Reference: 12S1395000

23 January 2015

**RE: CENTRAL PARK, BROADWAY – BLOCK 4N STATE SIGNIFICANT  
DEVELOPMENT APPLICATION FOR A MIXED USE BUILDING (SSD 6673)**

Figure 3.1: Proposed Vehicular Access

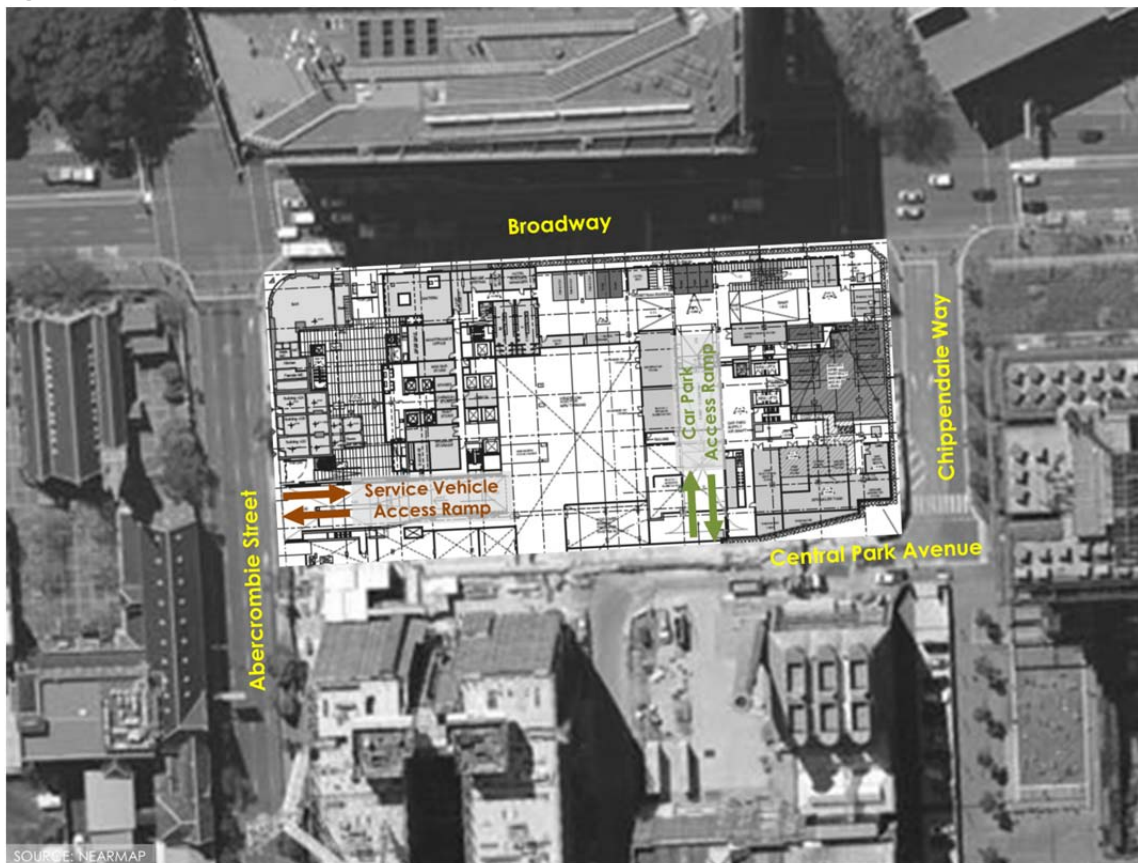
*Further consideration and review of the loading dock driveway access from Abercrombie Street to reduce the width or provide two separate crossings with a pedestrian refuge.*

It is understood that the intent of DPE's comment is to reduce the walking distance for pedestrians across the proposed driveway either in a single crossing movement or in a staged manner by way of a pedestrian refuge island.

It is noted that the current proposed design of the driveway fully complies with Australian Standard AS2890.2:2002. The entry lane has a width of 4.0m while the exit lane has a width of 3.5m. The entry and exit lanes are separated by a 0.8m wide island. The total width of the driveway is 8.3m.

The width of the entry and exit lanes have already been minimised to enable an Australian Standard 8.8m long medium rigid vehicle (MRV) to enter and exit the driveway without conflicting with the design requirements set out in the Australian Standard.

The provision of a refuge island without widening the driveway will adversely affect the safety of pedestrians using the refuge island as vehicles turning to and from the driveway would need to overrun the refuge island area. The vehicle swept path diagram shown in Figure 1 also highlights the vehicle swept paths overlapping into where the refuge island would be, if one was to be provided.

Finally, as to whether the proposed width is an acceptable distance for pedestrians to cross, it is noted that the Australian Standard AS2890.2 allows pedestrians to cross an access driveway with a total combined (entry and exit) width of up to 12.5m (Figure 3.1 of AS2890.2) or an entry lane width of 10m and an exit lane width of 10m if separated by a 1.5m wide island (Figure 3.2 of AS2890.2). In this case, the proposed total combined driveway width of 8.3m is significantly less than the requirements set out in the Australian Standard.

In summary, we believe that the proposed pedestrian crossing width is acceptable and could not be made wider to provide a pedestrian refuge without significantly affecting the aesthetic design of the building
